SPACE IN TIME
ARCHITECTS & INTERIOR DESIGNERS
PARTY WALL SURVEYORS

13 January 2021

Ref: Planning Application AB/109/20/HH – White Cottage, 32 King Street, Arundel BN18 9BW

PROPOSED ELEVATIONS

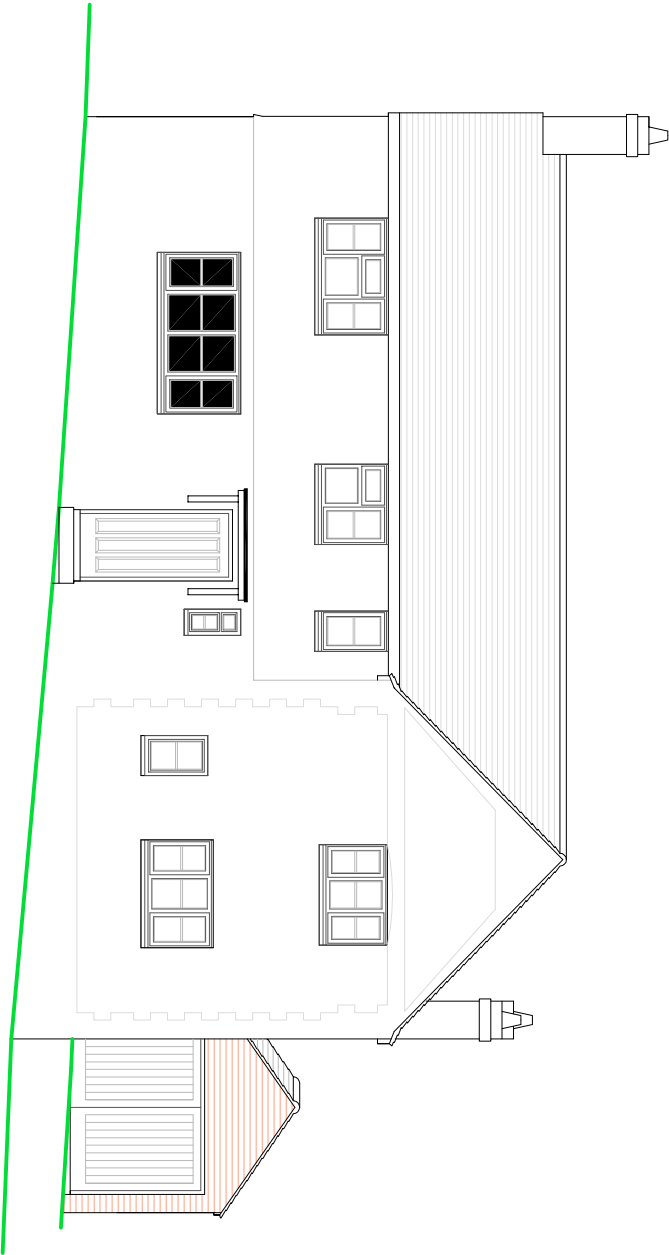
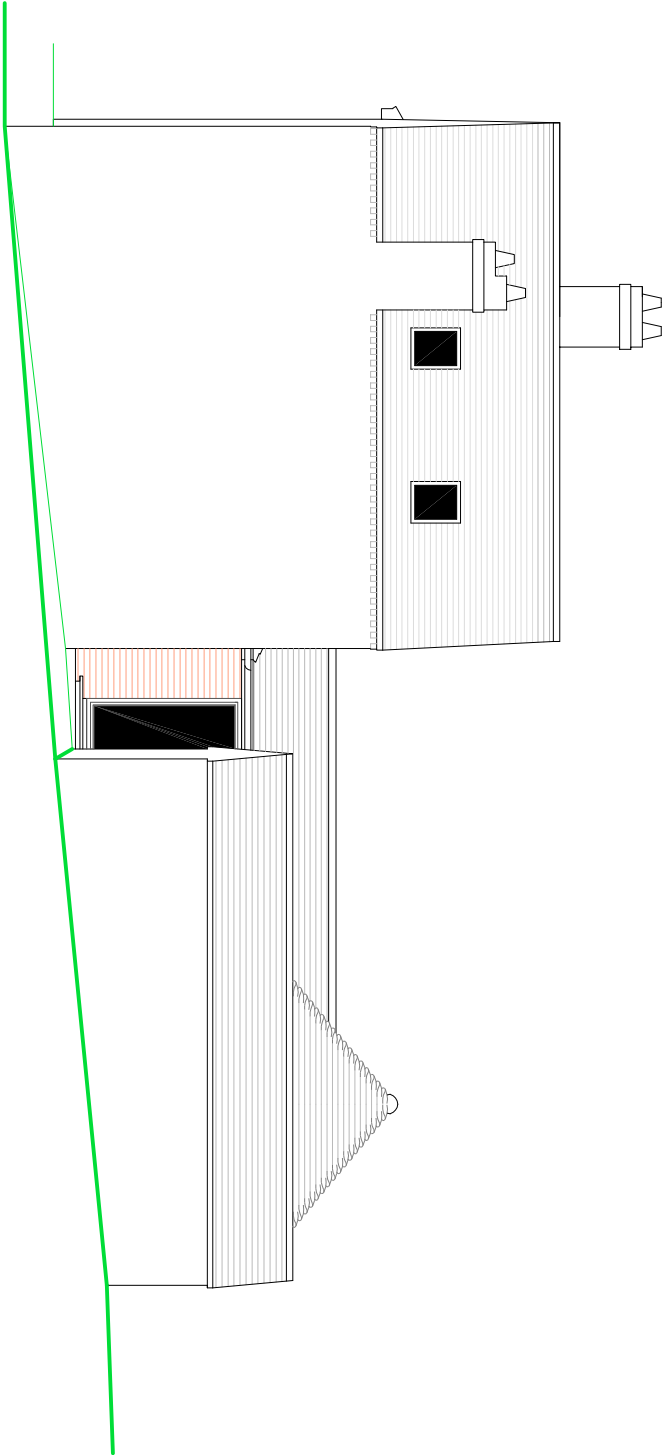
The Applicant proposes to take out 7-8 metres of this unique hedge together with all the wildlife habitats and established wildlife corridors, runs and trails and replace it with a blank brick wall, 4 metres in height with a truncated pitched roof of a further 1.5 metres. This wall would be on the boundary line, 1.4 metres from my client's property and his Living room and Study windows, which for 250 years have had quiet enjoyment of the garden and beech hedge through which the sunlight filters.

The loss of amenity is severe. Daylight will be reduced to almost zero in the winter months and sunlight in the Summer, to a few hours. This falls far short of the **Daylight/Sunlight Assessment** calculated in accordance with the **BRESITE Layout Planning for Daylight/Sunlight**, a guide to good practice and British Standard BS8206-2. Furthermore, the windows in the property are entitled to **Ancient Lights status** and are protected under Prescriptive Rights, 1662. Therefore, the plan of the Applicant, if approved, could not go ahead in any case.
